Application No: EP/68/21/HH
Site Address: Merrydown Kingston Lane East Preston BN16 1RP
Description of works: Erection of timber framed detached garage with ancillary accommodation on first floor, installation of electric gated entrance, erection of new brick garden walls and extension to existing driveway and hardstanding.

Thank you for your internet representation made on 13th July 2021 which has been recorded as an objection with the comments as follows:

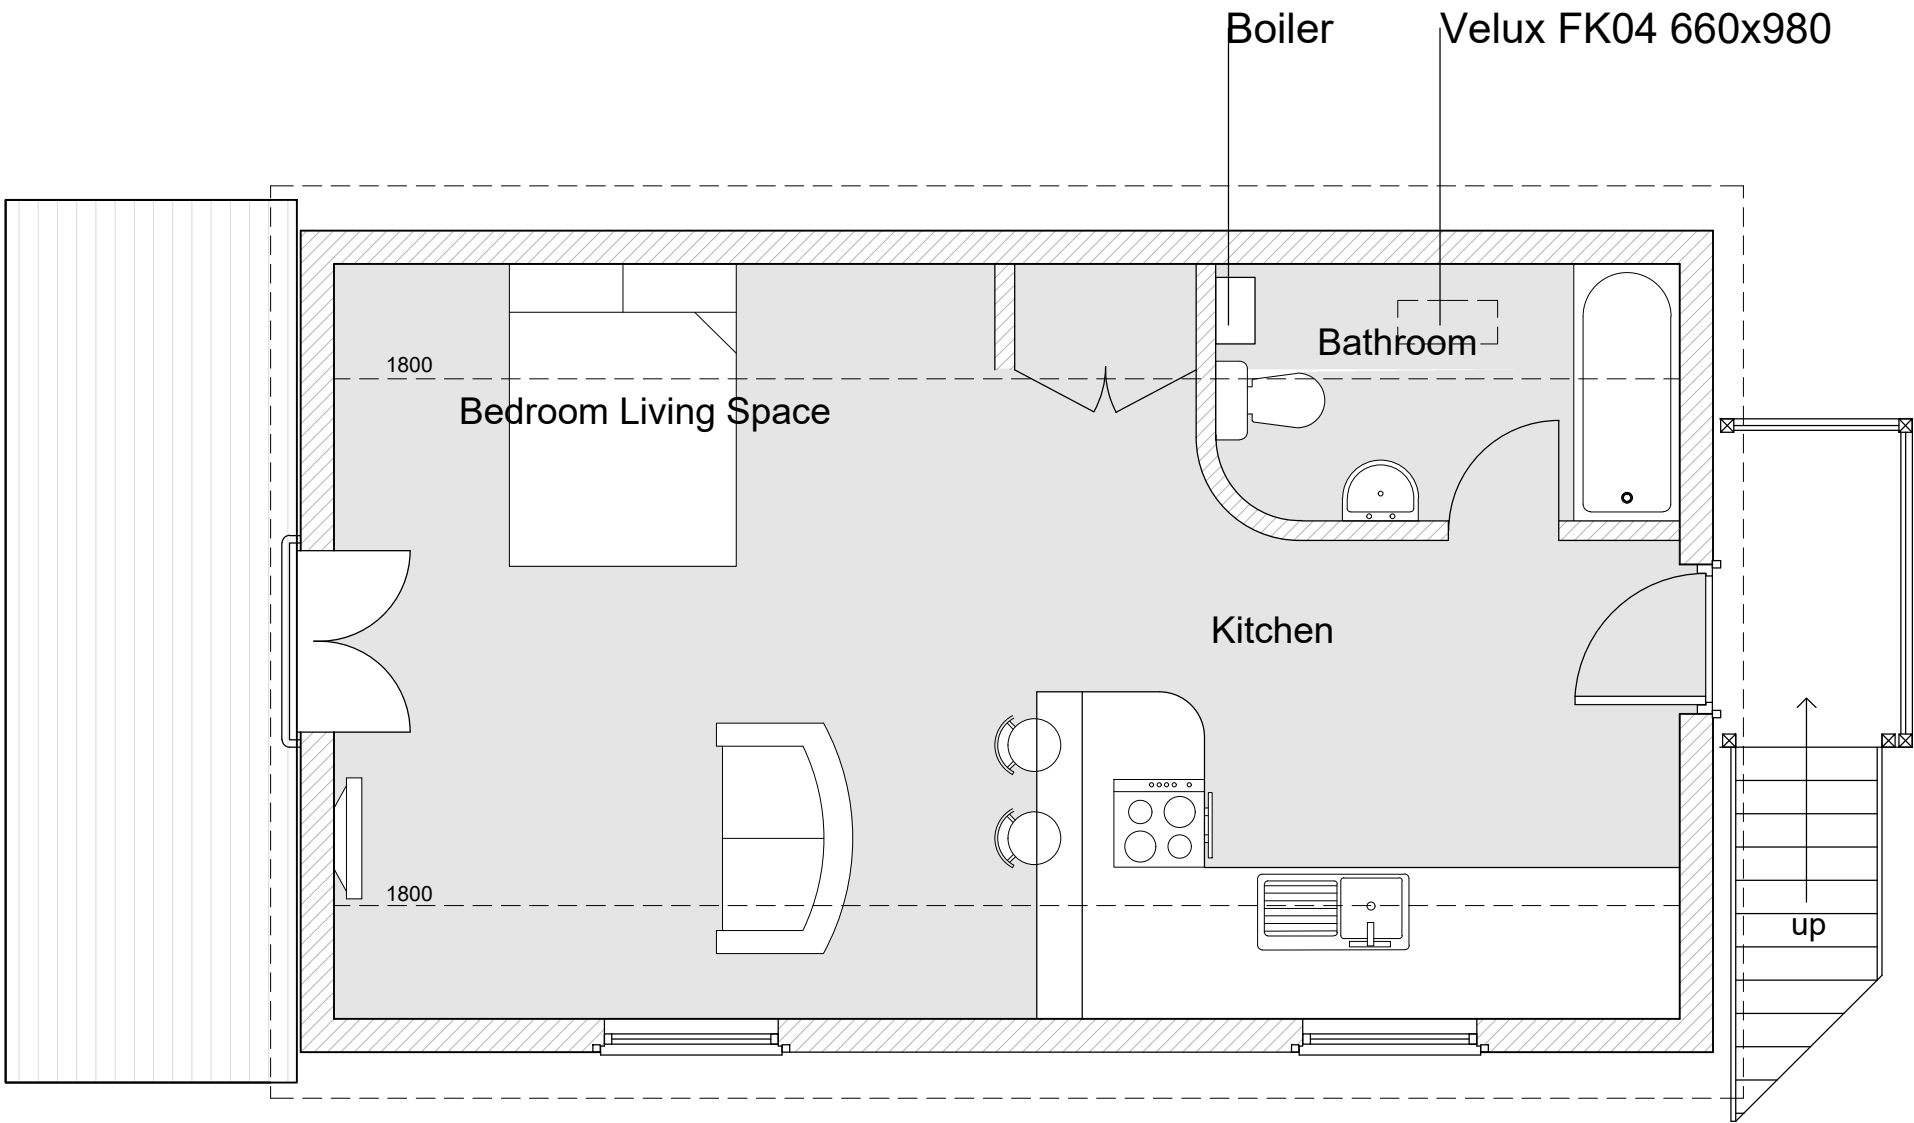
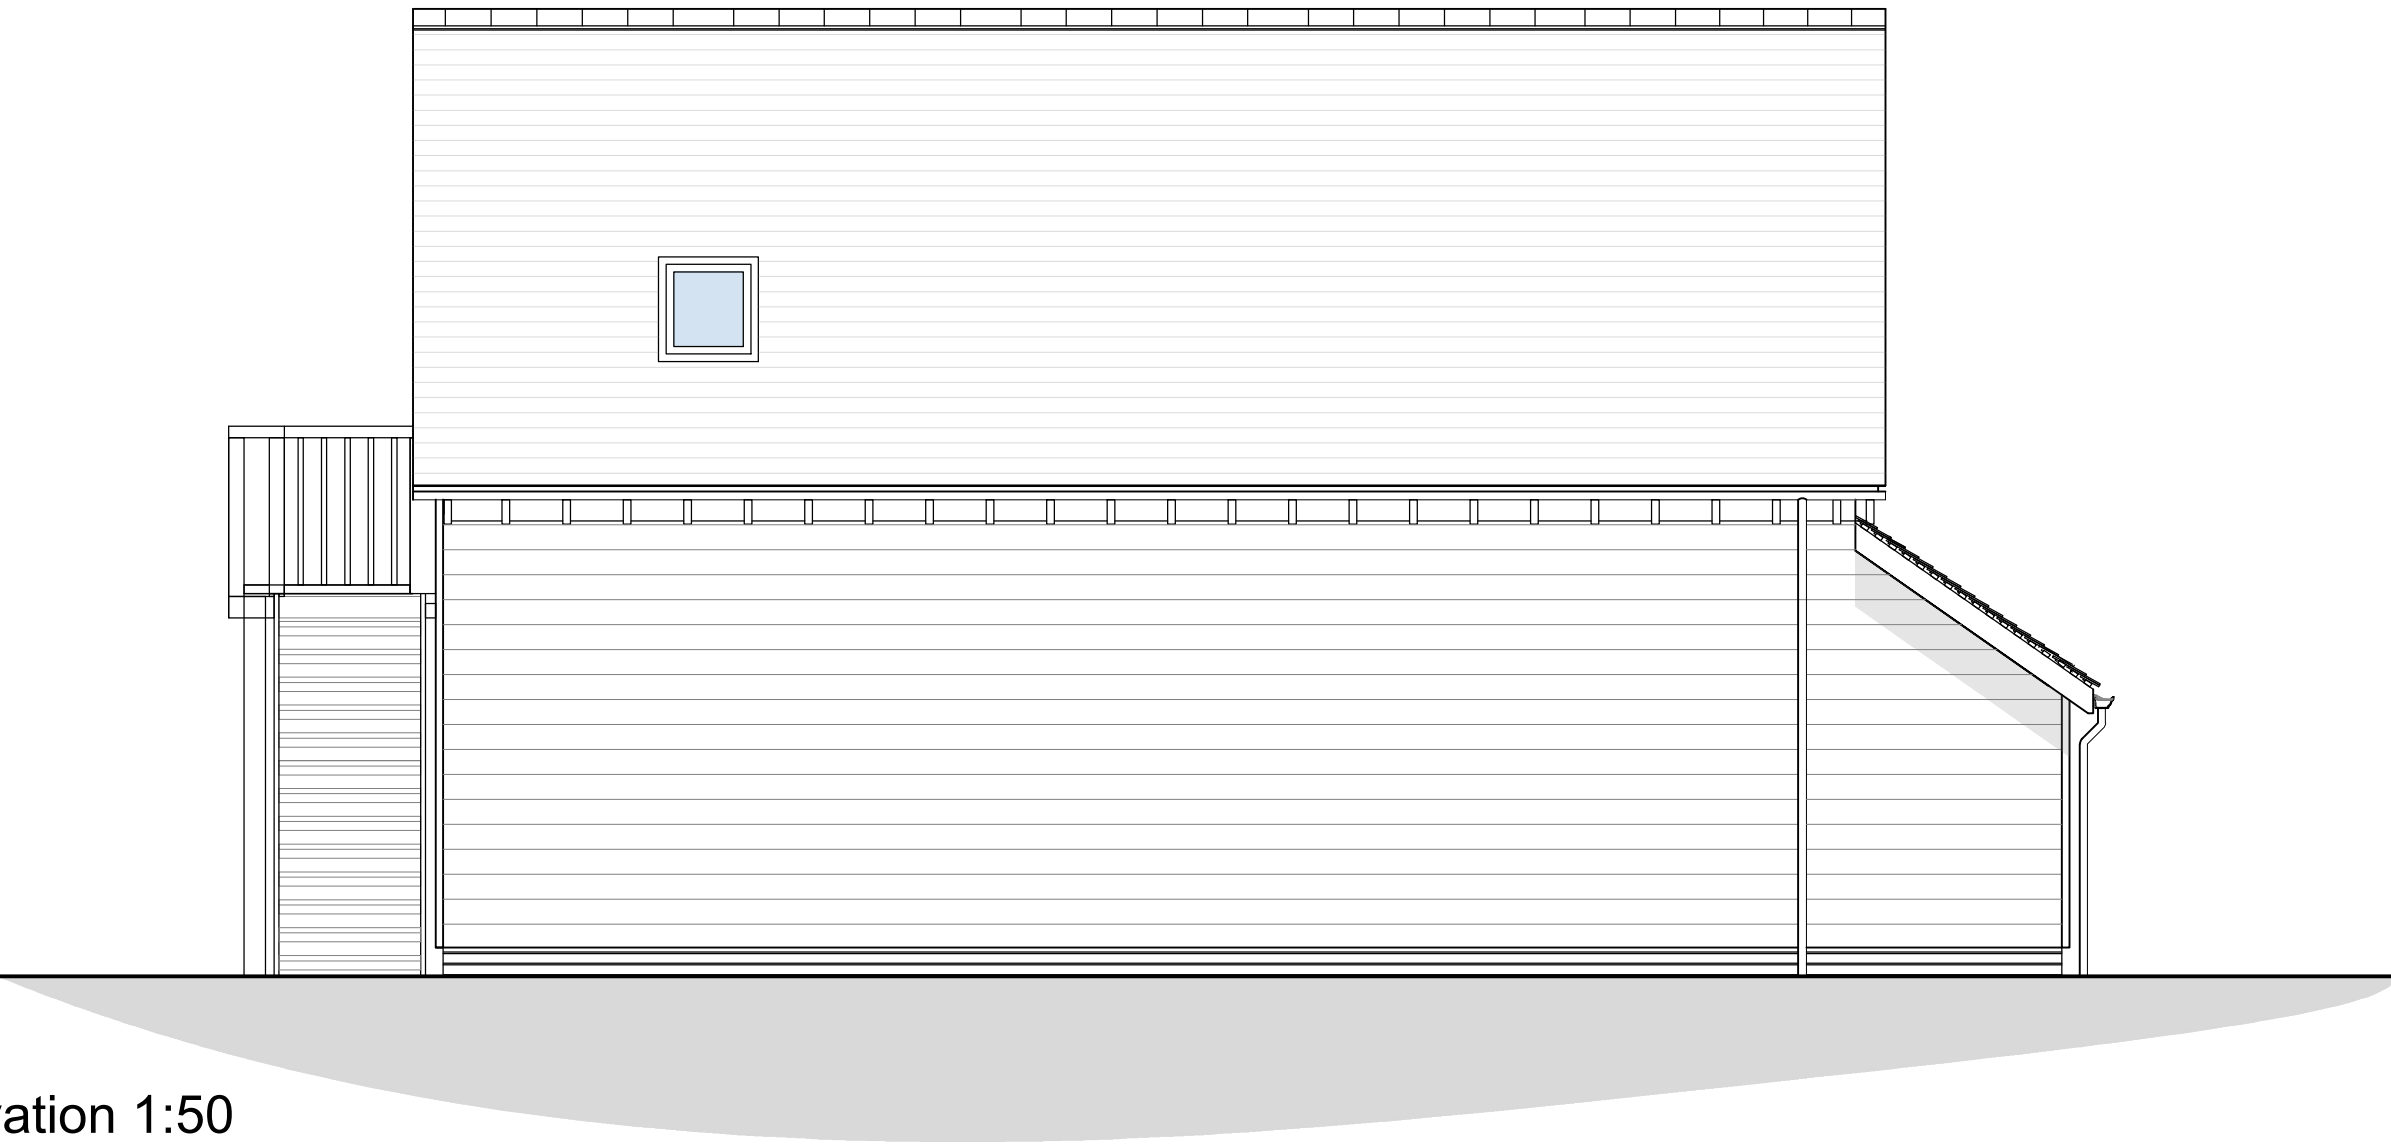
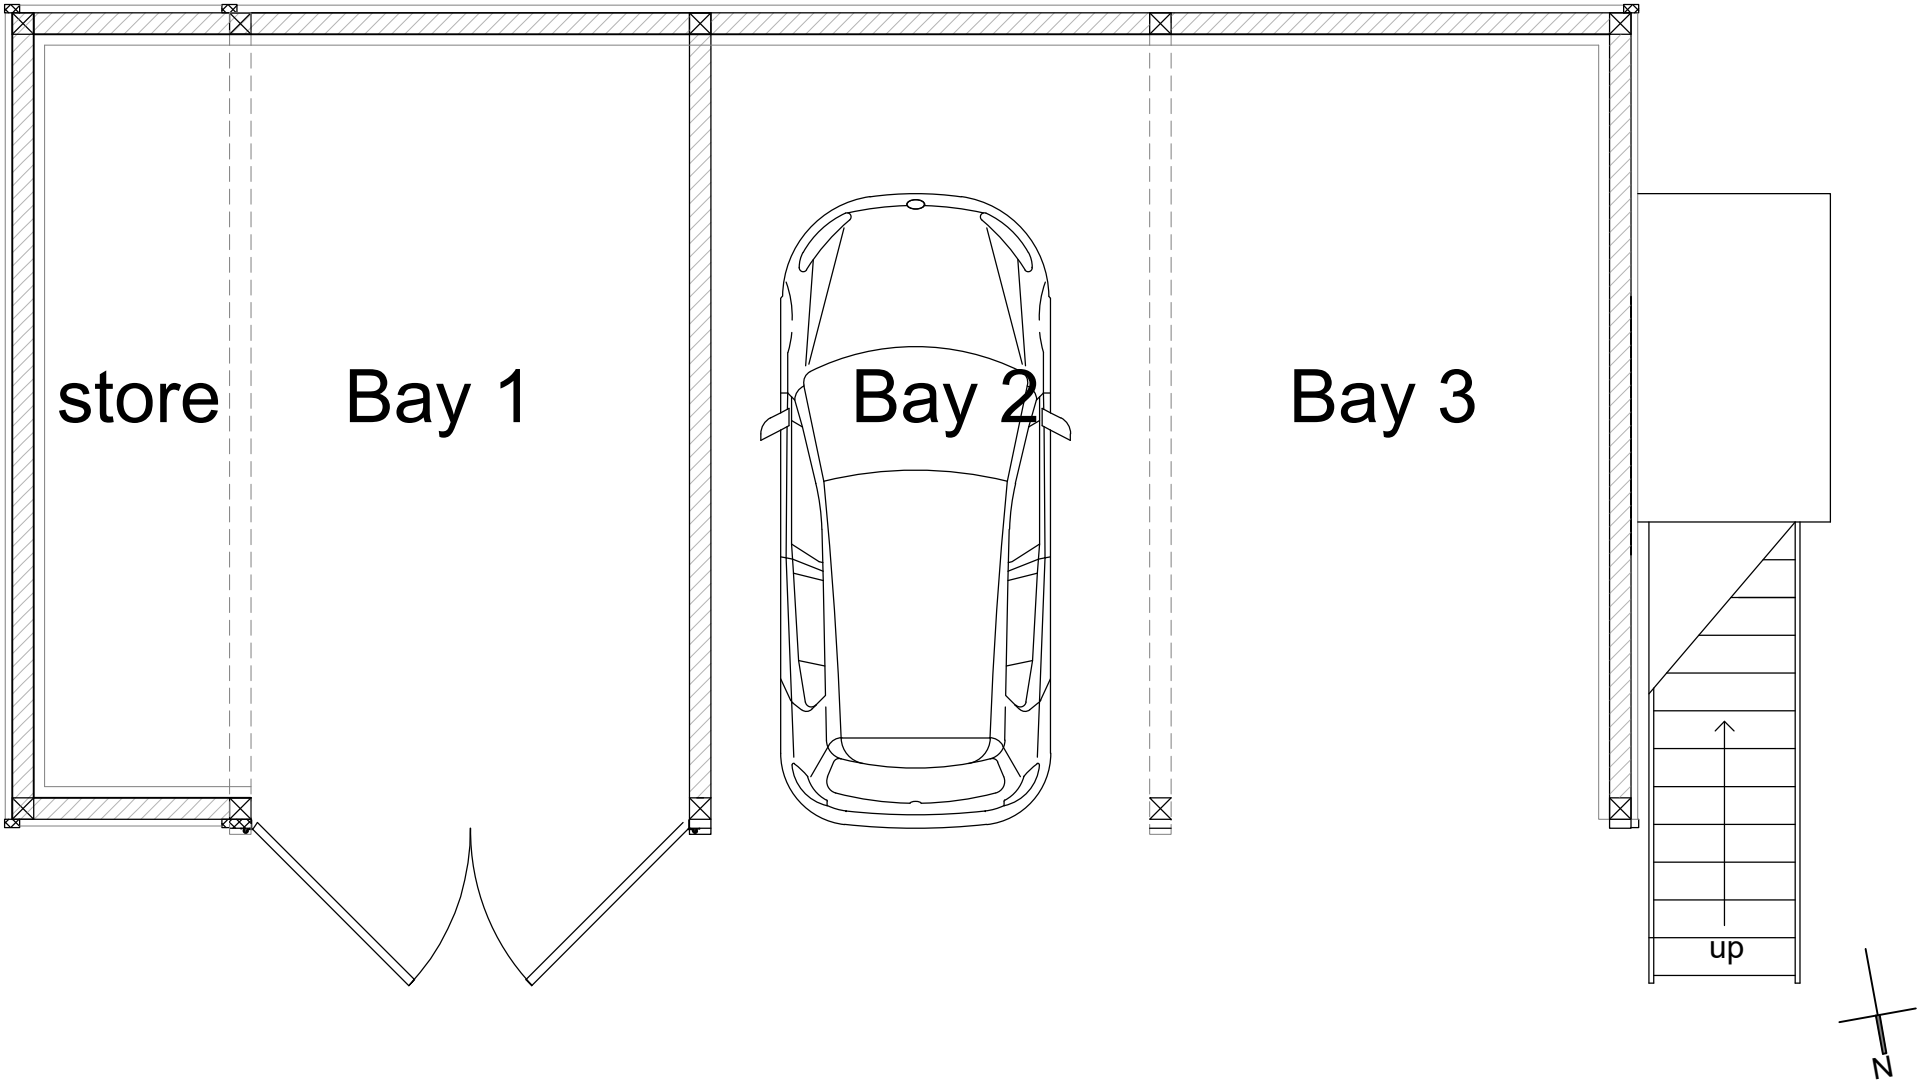
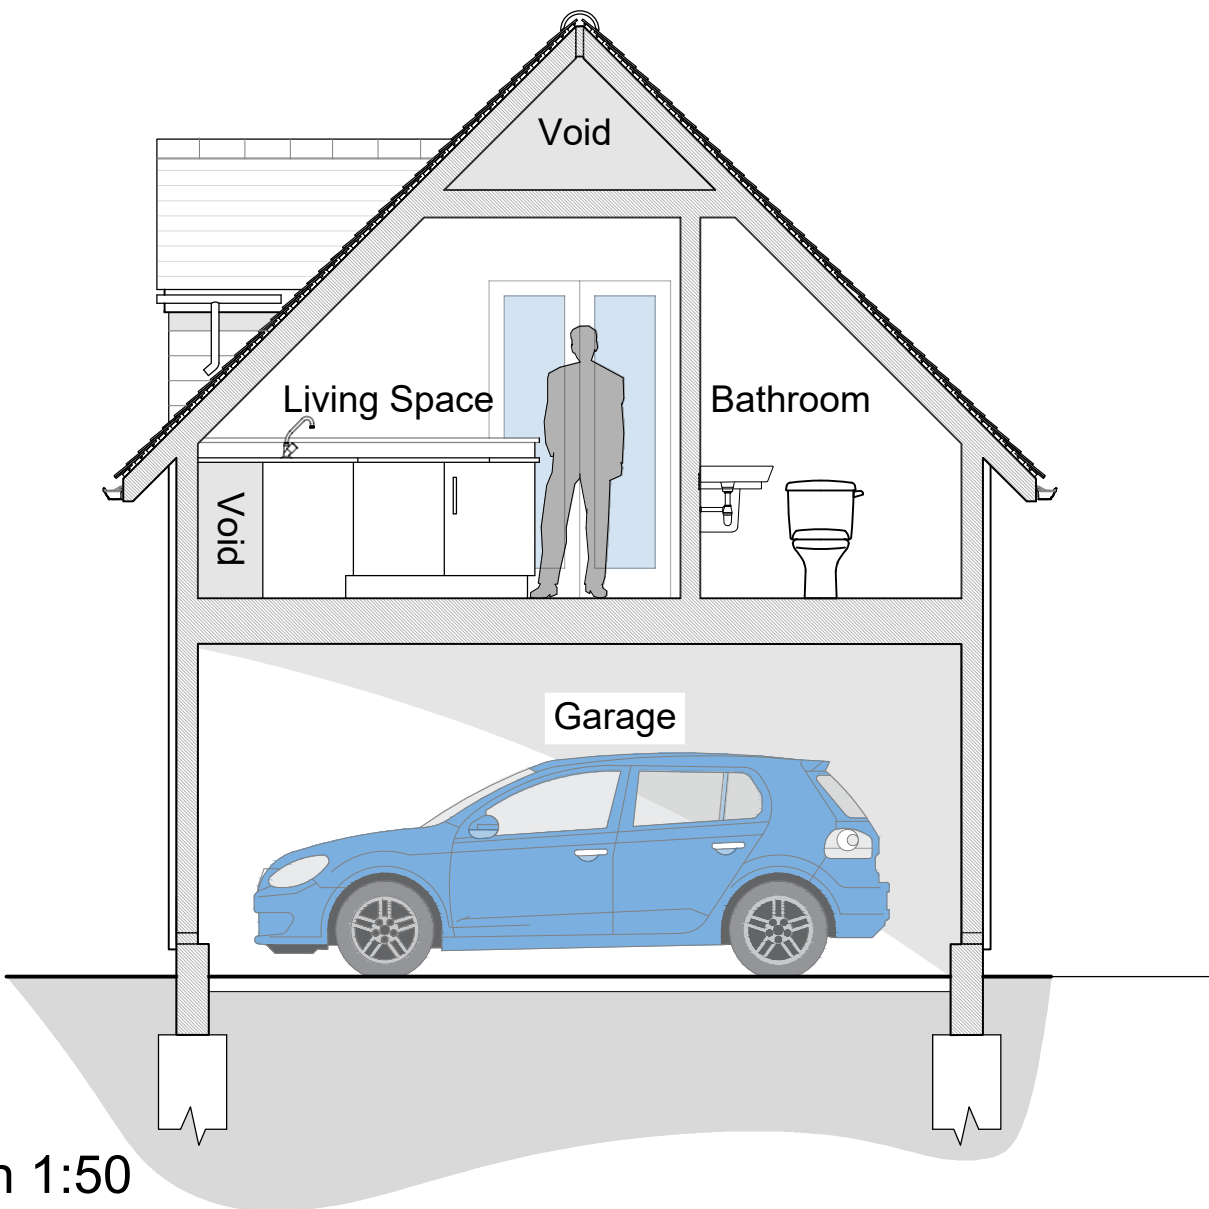
Proposed first floor accommodation may block views of open fields and tree lines from our house.
